# CITY OF ALBUQUERQUE

**Re: La Cuentista Subdivision and La Cuentista Units 1 and 2 Drainage Reports  
Engineer's Stamp Date 12/29/03, 6-20-06 and 1-23-07**

Based upon the above listed submittals, additional information in the form of an Addendum to the La Cuentista Unit 2 Drainage Report is required prior to Hydrology approving the recent application for platting action of La Cuentista Unit 2 at DRB. The following comments are to be addressed:

PLATE 1

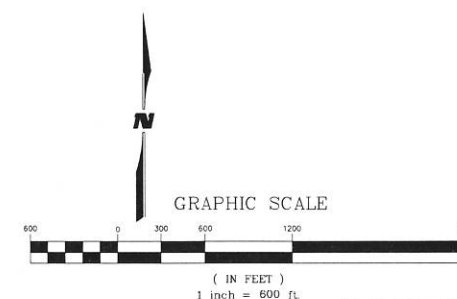
1. Provide a revised existing conditions basin map, with calculations, that includes the recently built Unser Blvd and the culverts under the road.
2. Show how existing flows are accepted including calculations. Include the area inlets upstream of La Cuentista Units 1 and 2. New survey data will most likely be required for the area inlets as grading has occurred near the area inlet upstream of Unit 1 since the area drain was built and there are large rock stockpiles upstream of the area inlet near Unit 2.
3. The storm drain in Rosa Parks near Kimmick Dr, outfalls into Tract D Block 0 of La Cuentista. Since this is a public storm drain a Public Drainage Easement is required on Tract D. In addition, since it is a temporary solution, a recorded Agreement and Covenant for private maintenance of the ponding area is required.
